Beacon Fen Energy Park (Project Reference: EN010151)

Boston Borough Council's

Local Impact Report (LIR)

© Copyright Reserved  
N:\ST19595-SOLAR PV\DCO BECKER FEN\03-DESIGN\AUTOCAD\ST19595-461-VEGETATION REMOVAL PLAN REV BECKER FEN SUBSTATION UPDATED.DWG

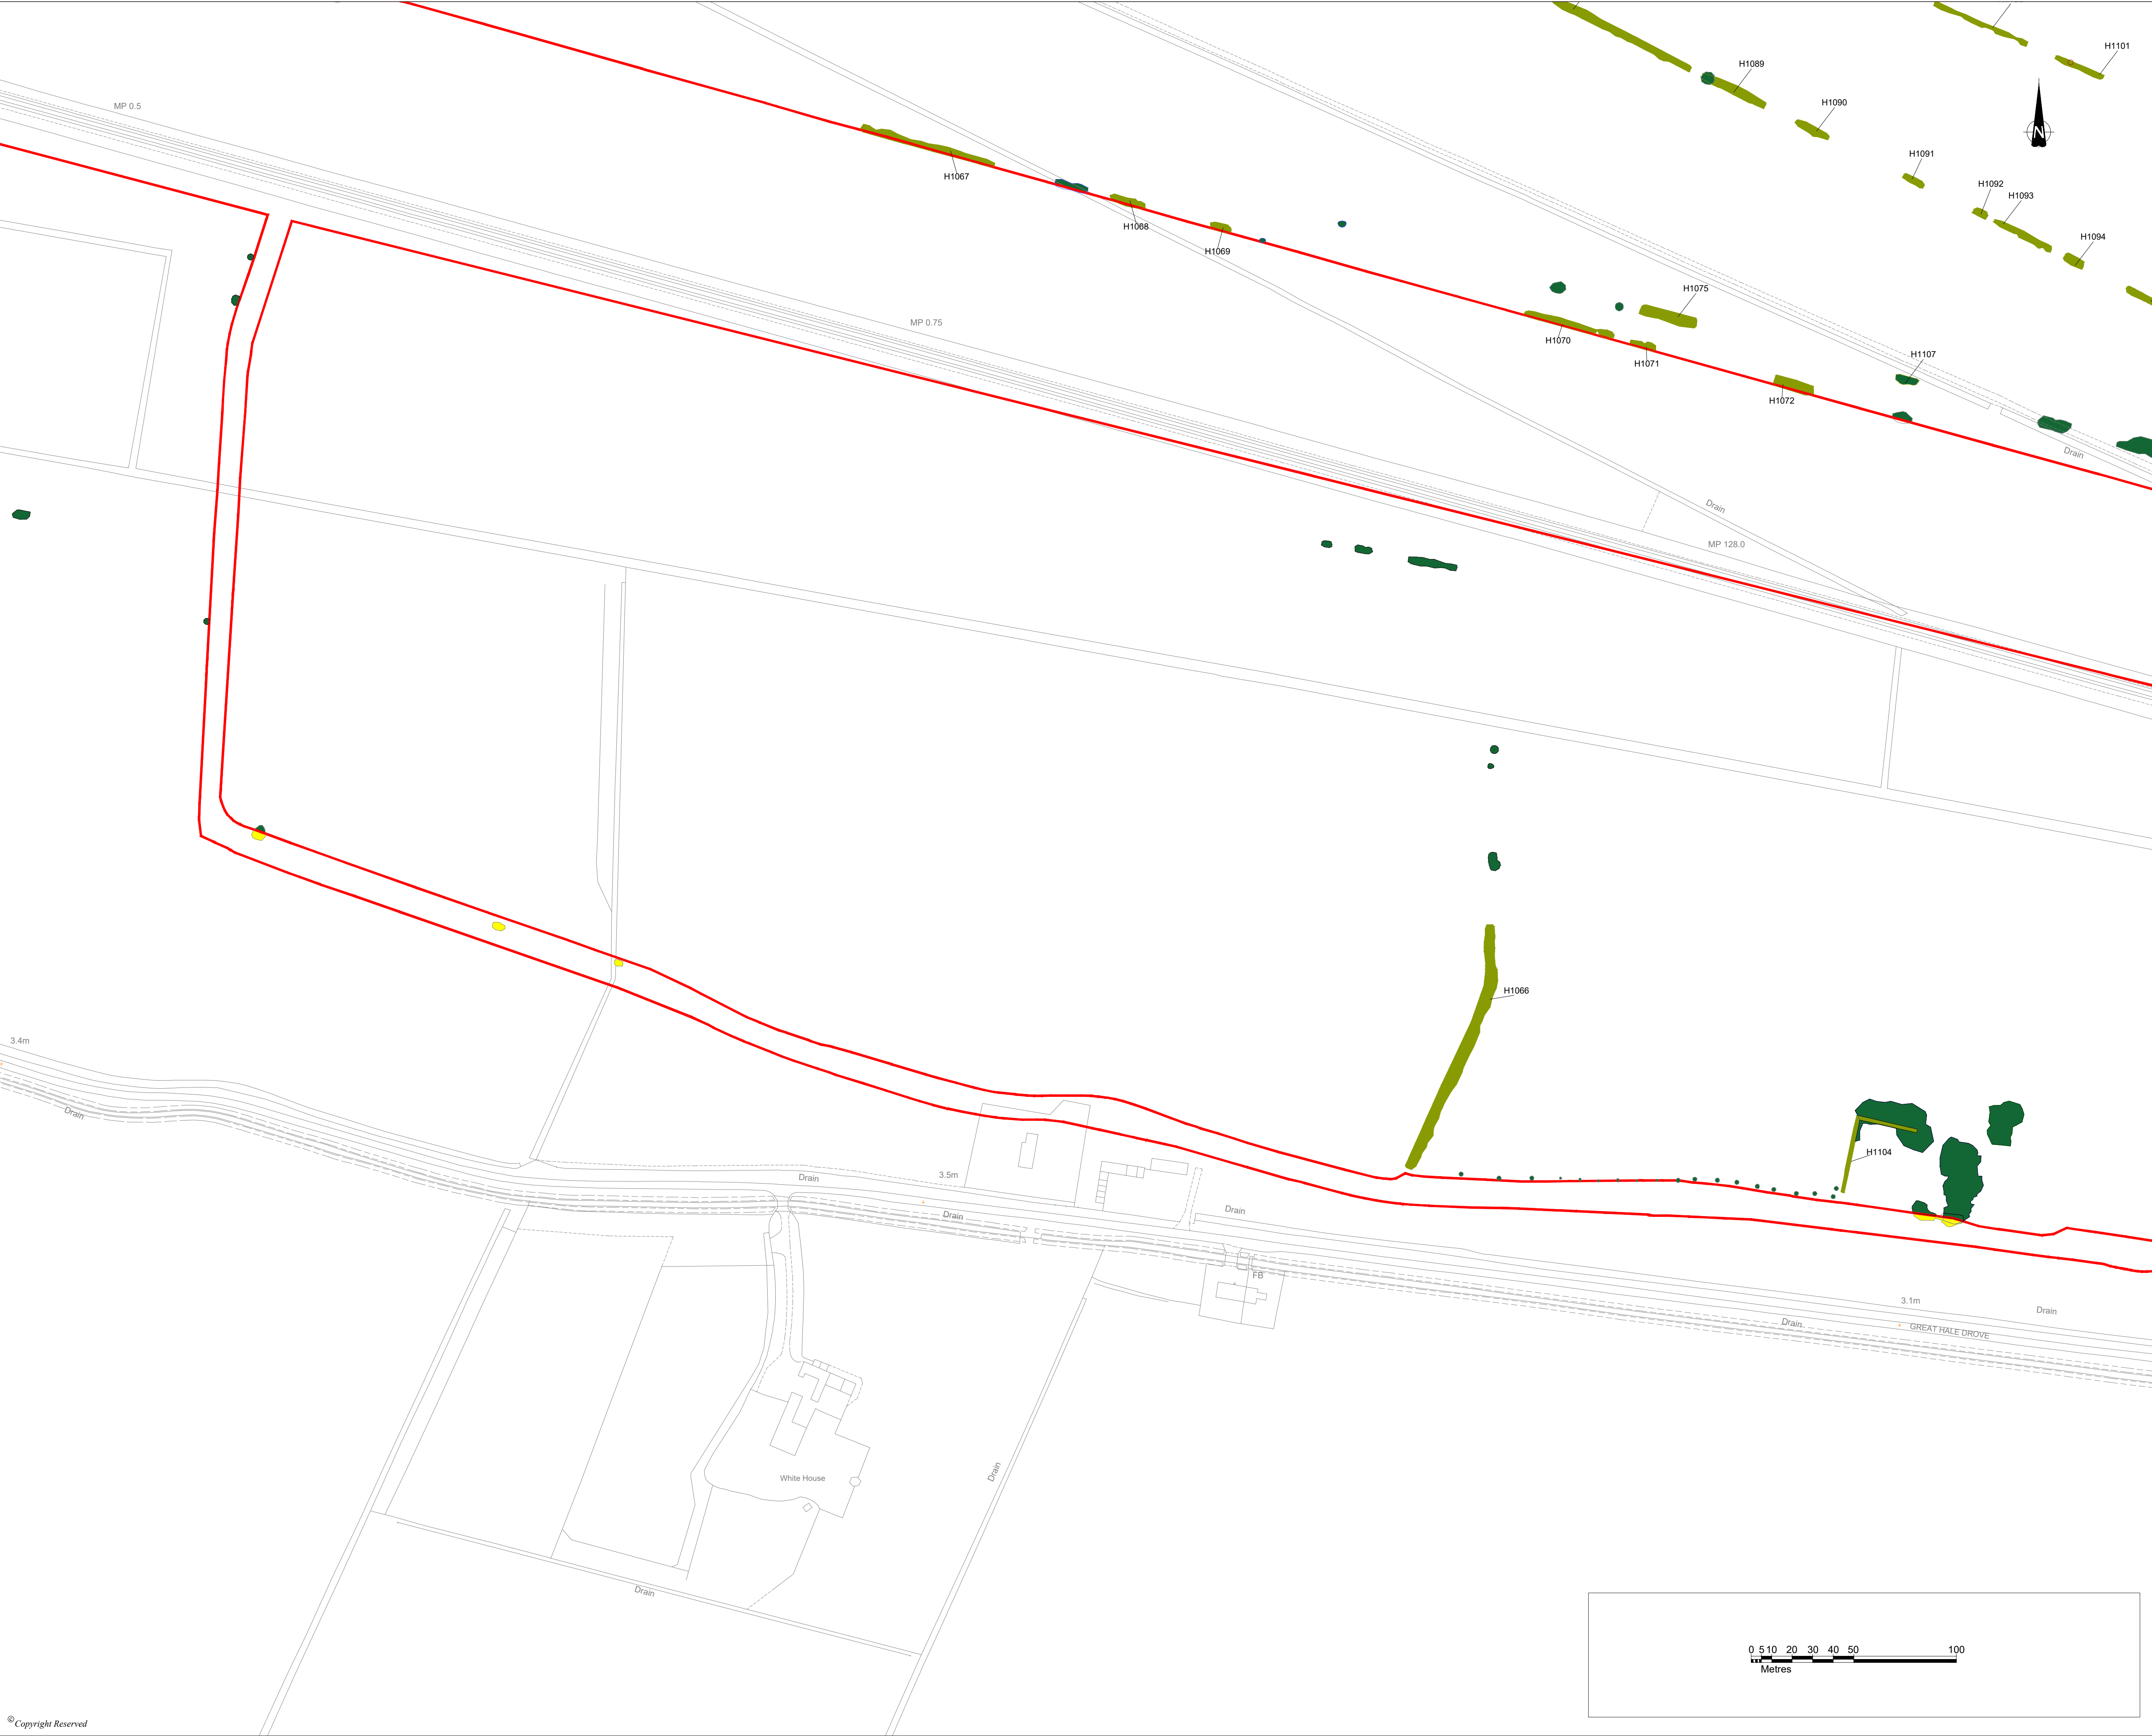
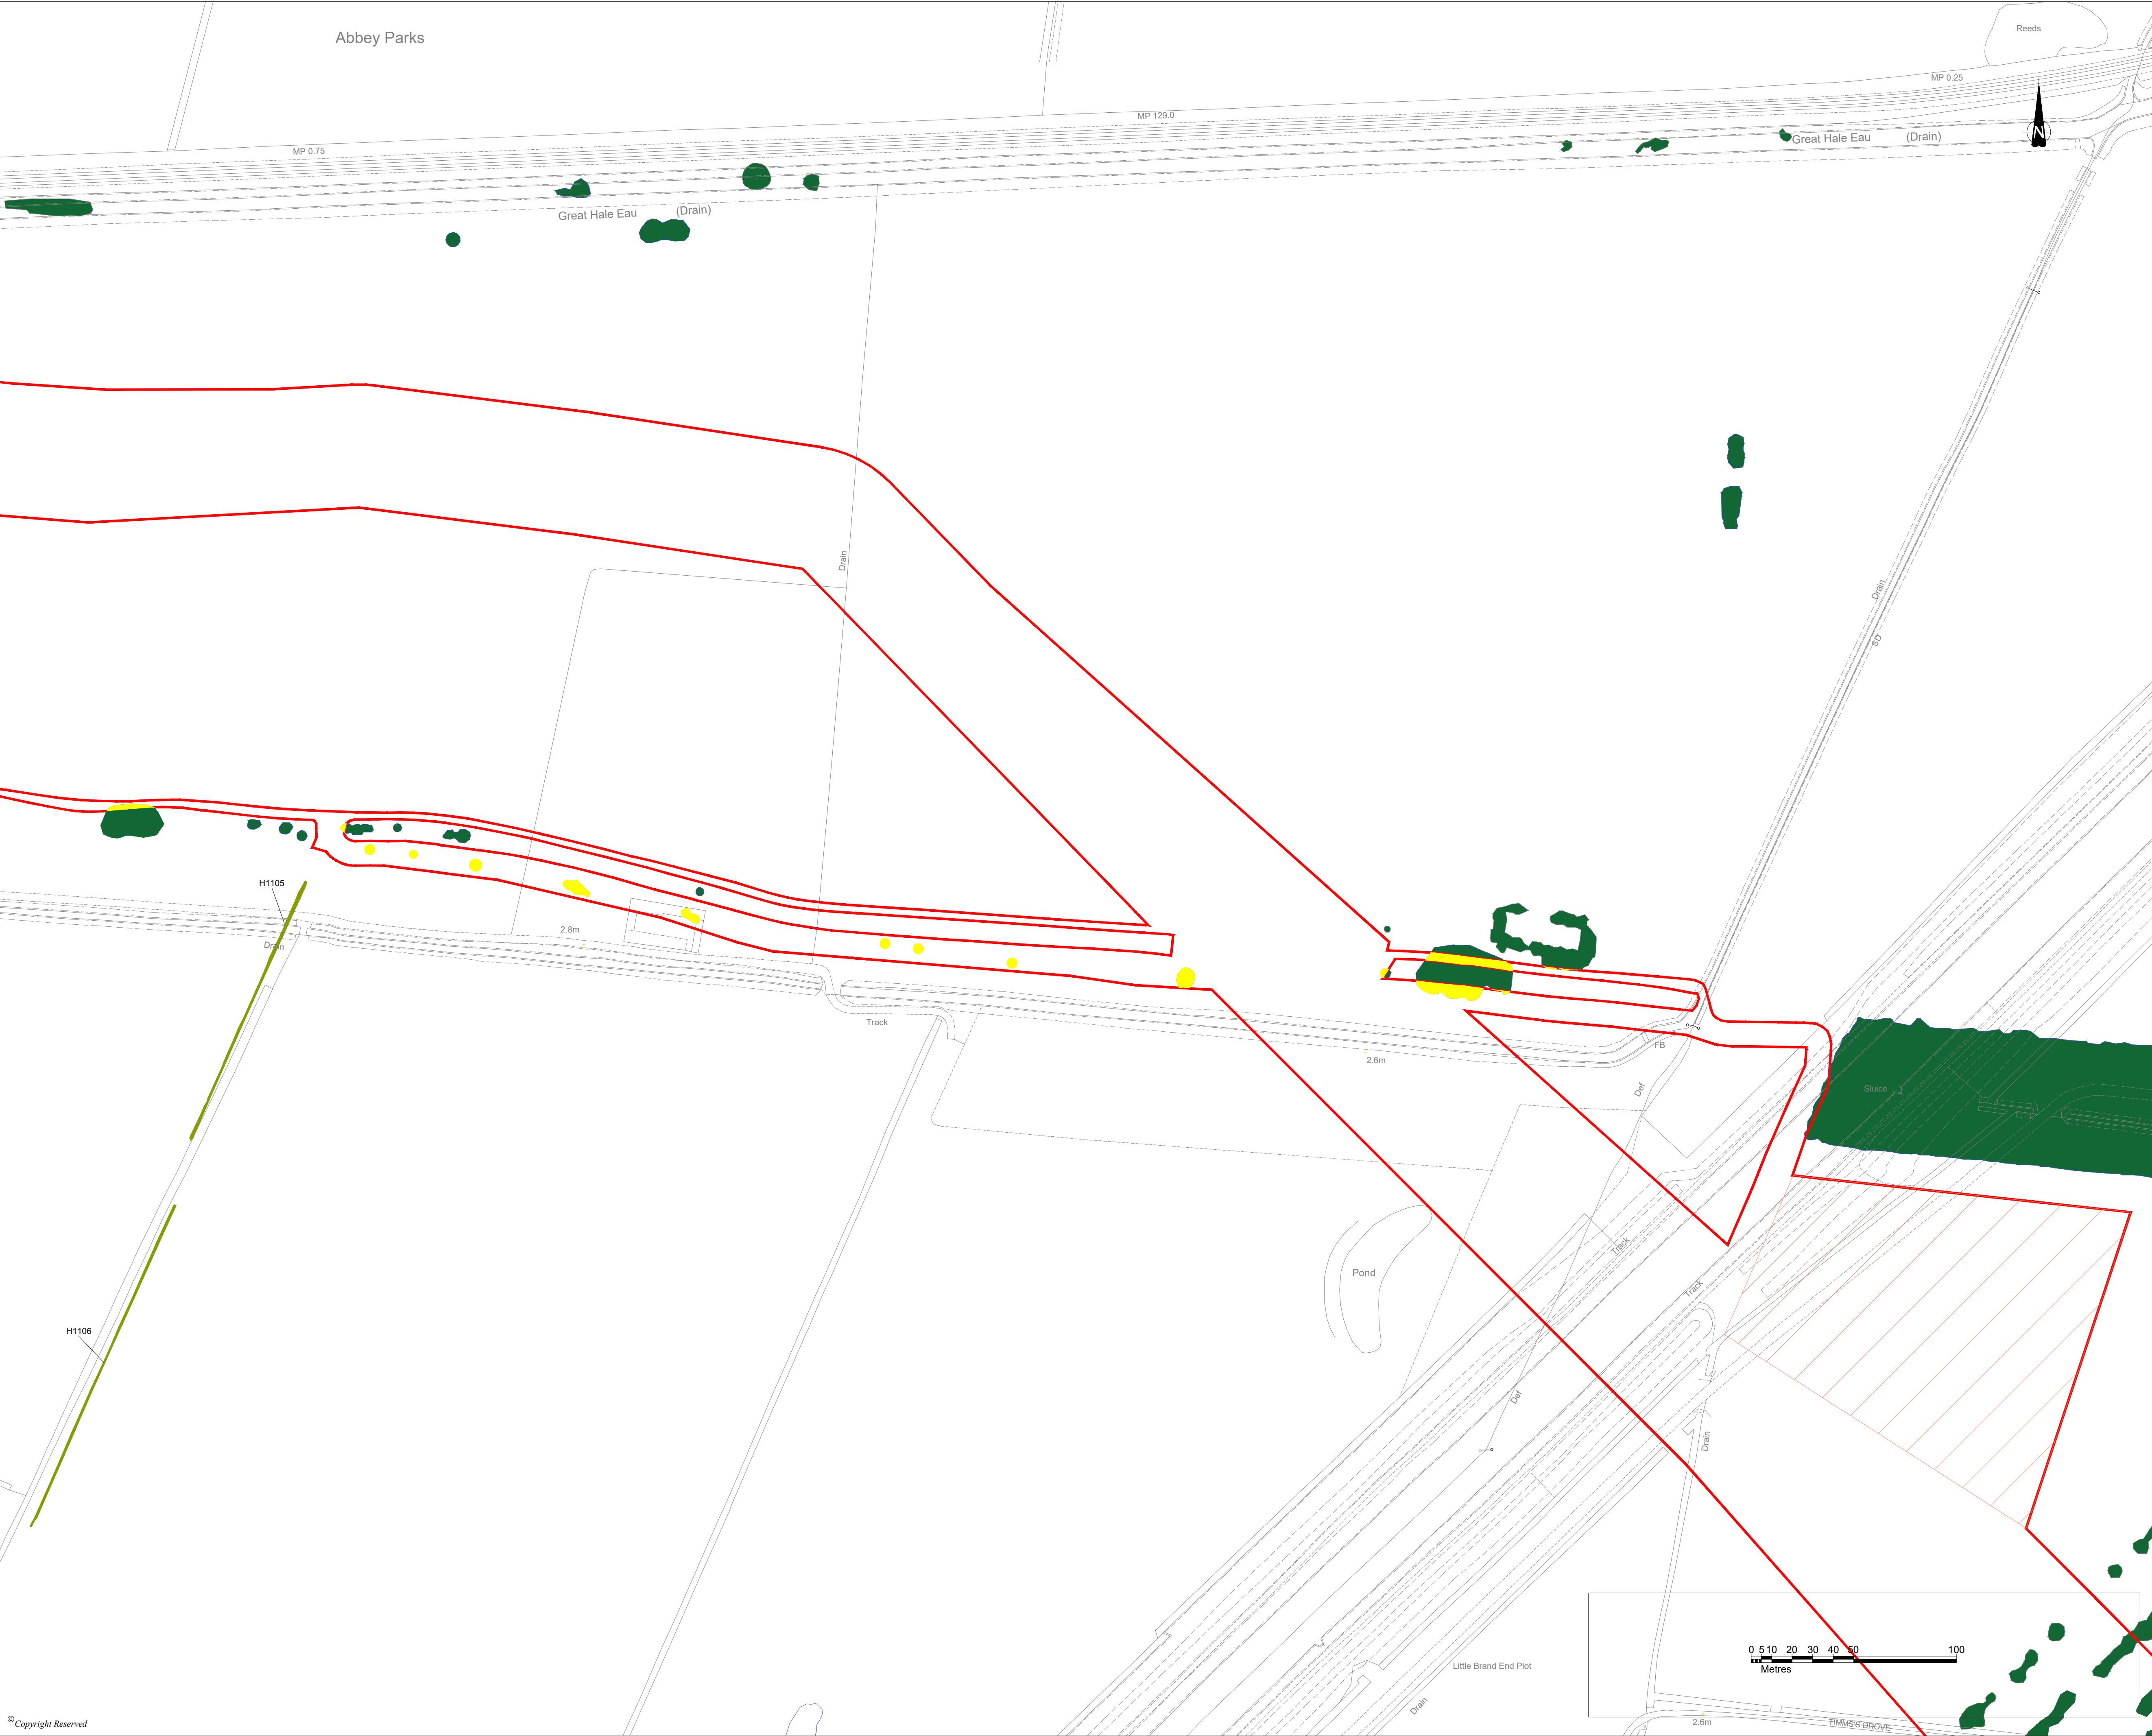
- Vegetation Removal at the extension to Bicker Fen Substation- Vegetation Removal Plan 6.4.43c Fig 6.32 doesn't clearly show the same vegetation removed as above. The Applicant should provide clarification on Vegetation Removal Plans for the extension to Bicker Fen Substation i.e. potential to remove all the vegetation within the Order Limits associated with the Bicker Substation.

- Vegetation Removal at South Forty Foot Drain a LWS -Vegetation Removal Plan 6.4.43c Fig 6.32 (APP-237) appears to show the removal of all vegetation within the LWS South Forty Foot Drain when HDD crossing is Proposed. The Applicant should provide Clarification on Vegetation Removal Plans for South Forty Foot Drain as the Borough Council are not why there is the need to show potential removal when the crossing method is committed as HDD trenchless crossing.

- 5.4.5 Vegetation Removal Plan 6.4.43c Fig 6.32 shows all vegetation removed (potentially) despite the crossing being confirmed as HDD. BBC are concerned that if there is potential to remove all the vegetation within the LWS then the Applicants confirmed use of the HDD trenchless crossing to cross the South Forty Foot Drain may not be as fixed as the ES suggests.
- 5.4.6 There is therefore concern that the Impact upon South Forty Foot Drain a Local Wildlife Site where the cable corridor crosses it particularly in regard to the potential loss of vegetation and clarity upon the crossing technique to be utilised is uncertain and maybe worse if all the vegetation was removed and the crossing technique changed.
